ENG-SF18027-2024R1 - CDs.pdf Markup Summary

Subject:
Page Index: 1
Date: 3/26/2024 10:46:08 AM
Author: Jeff Rice - EPC Engineering Review
Color: 
Layer:
Space:
Page Label: [1] Layout1

RETREAT AT TIMBERIDGE FILING NO. 4			
CONSTRUCTION PLANS			
DETENTION FACILITY POND 4			
POND PLAN			
DESIGNED BY	MAW	SCALE	DATE 1-15-24
DRAWN BY	MAW	(H) 1" = 30'	SHEET 12 OF 14
CHECKED BY	(V) 1" = N/A	JOB NO.	1185.31

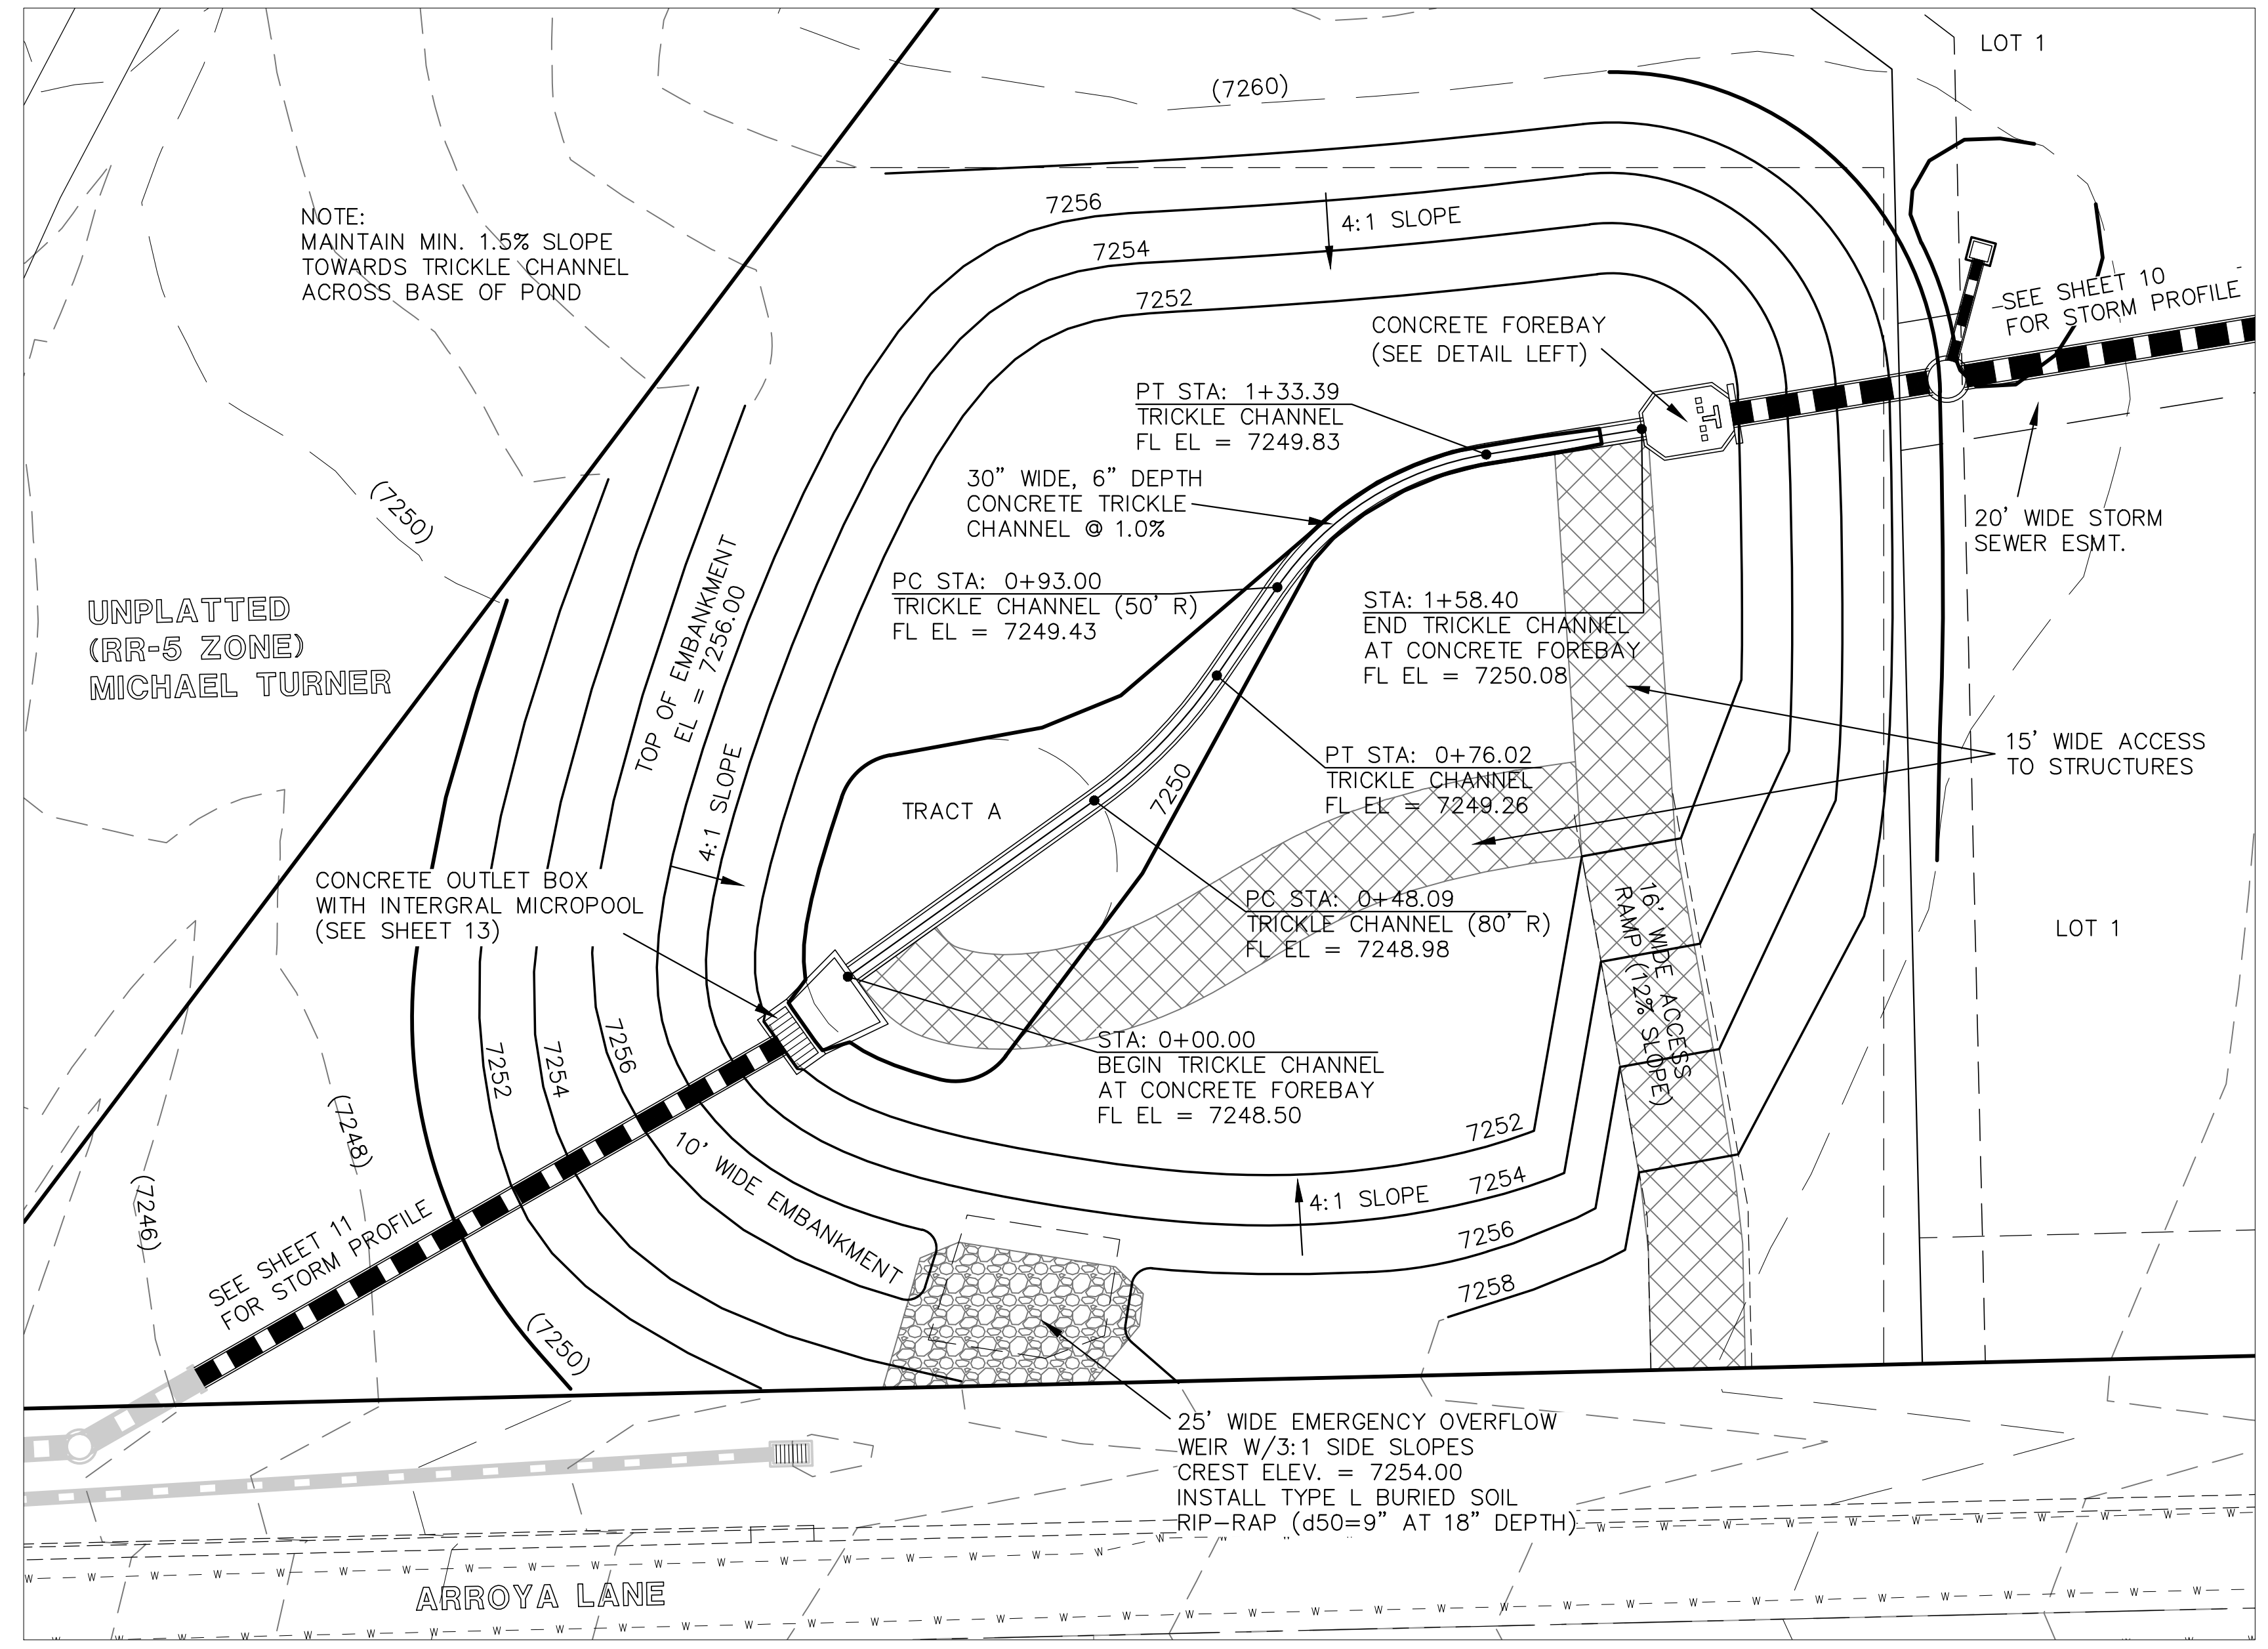
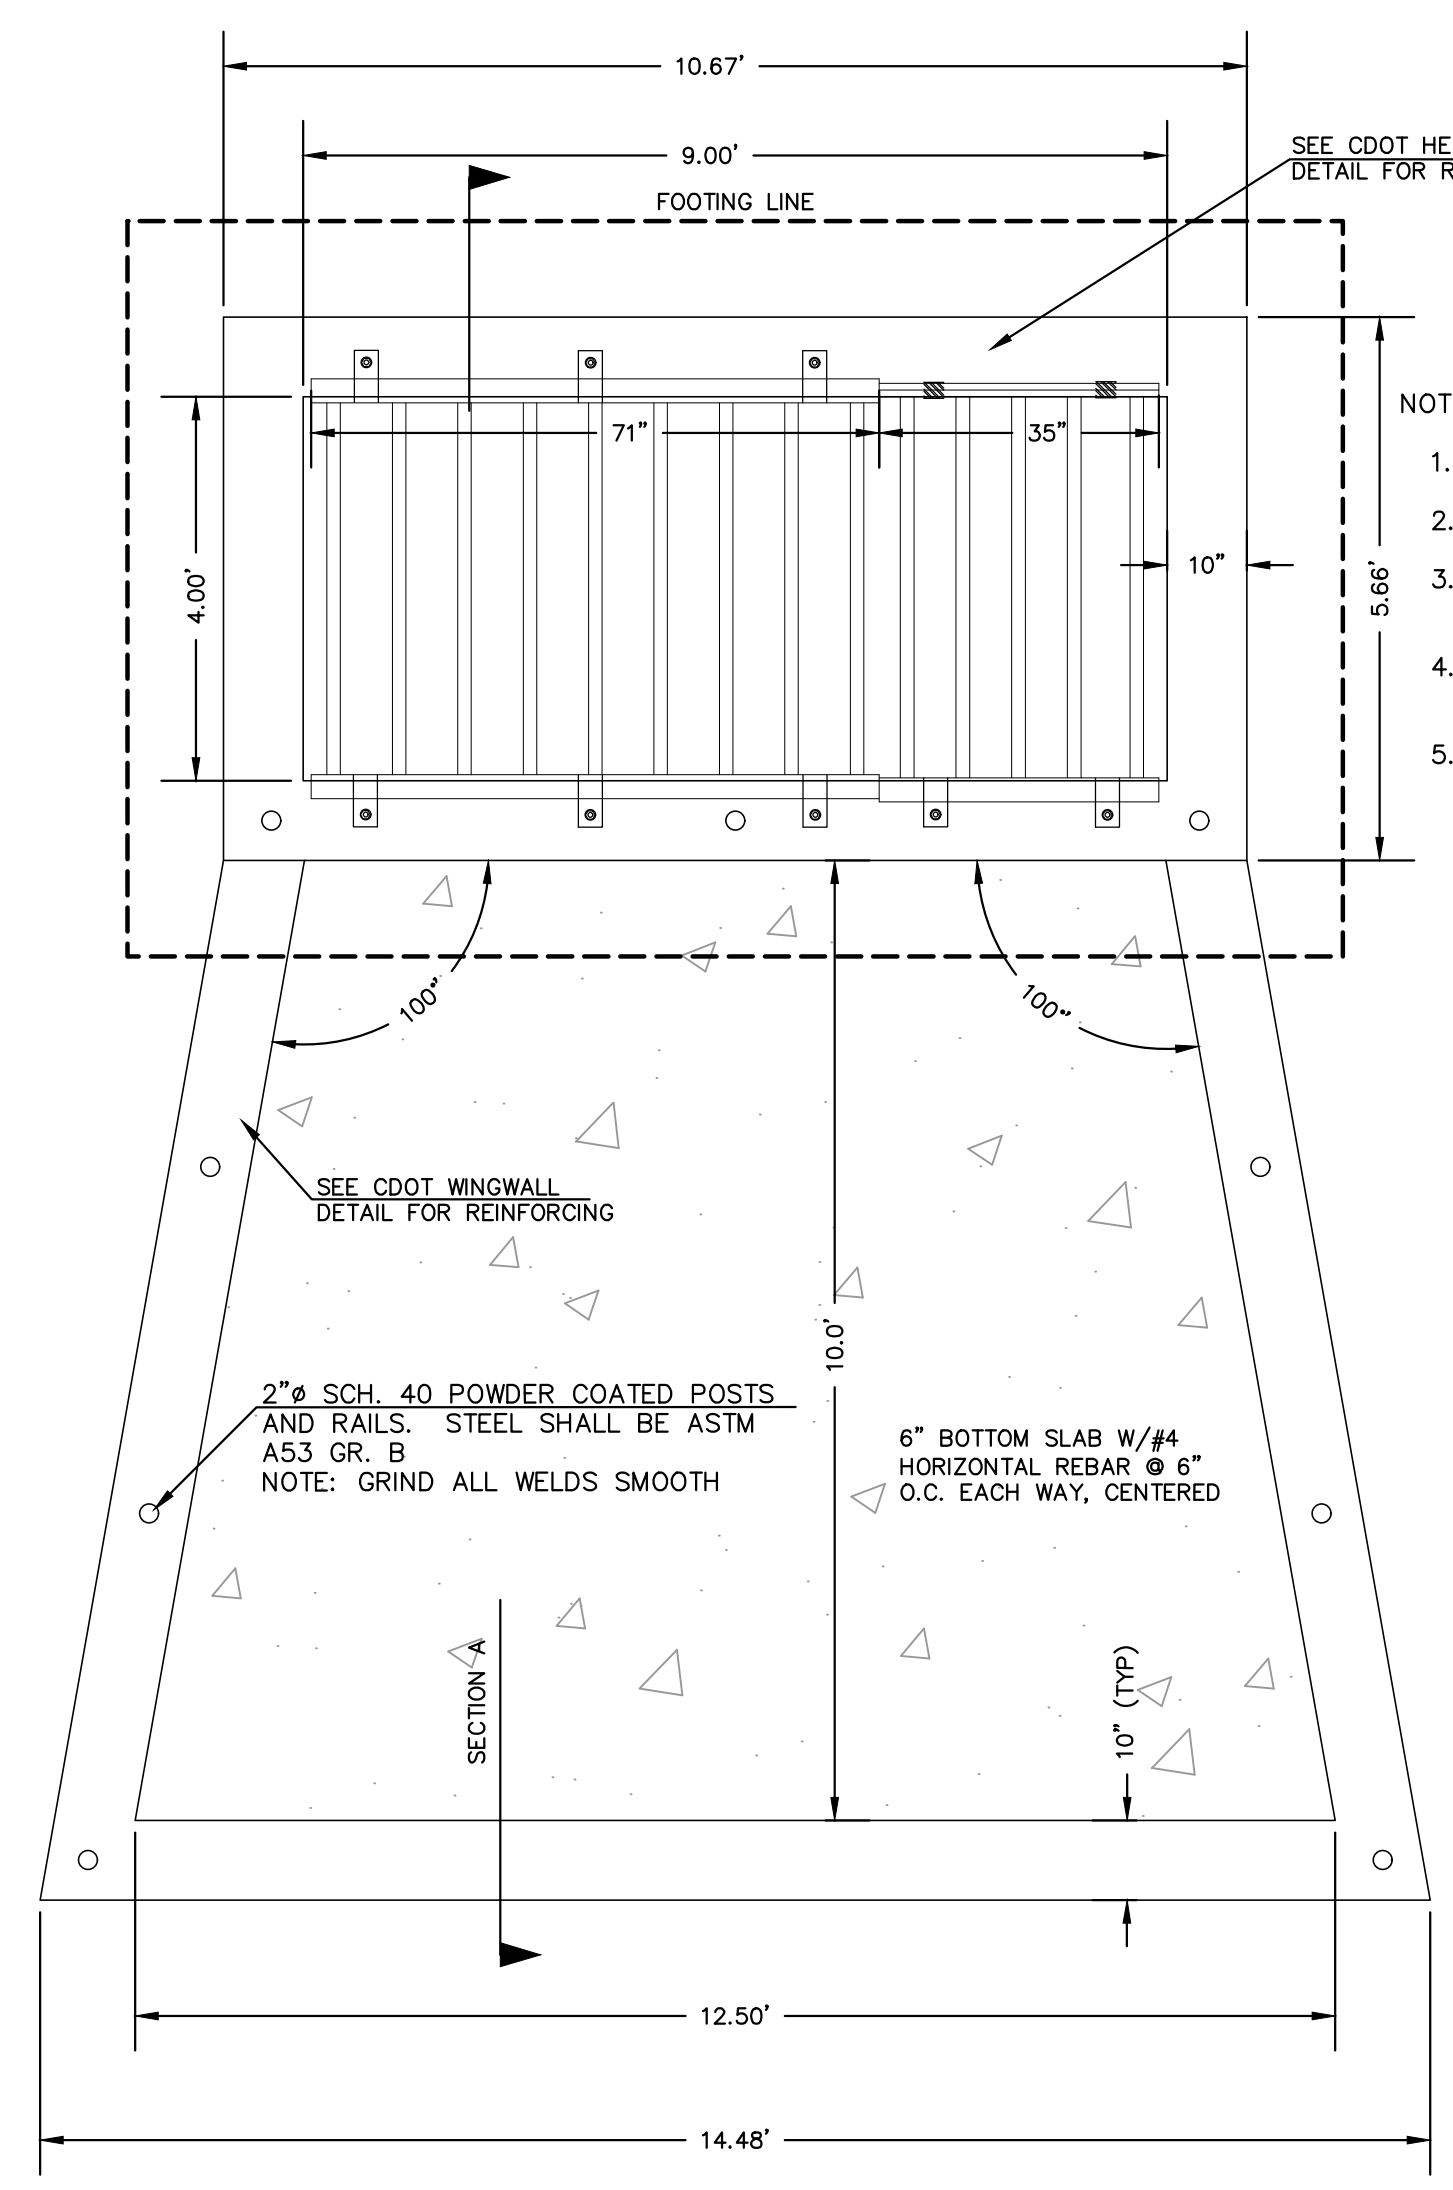
Show and label outlet protection

Label outlet protection

Label slope. Is protection needed with this steep of a slope?

See sheet XX for pond details
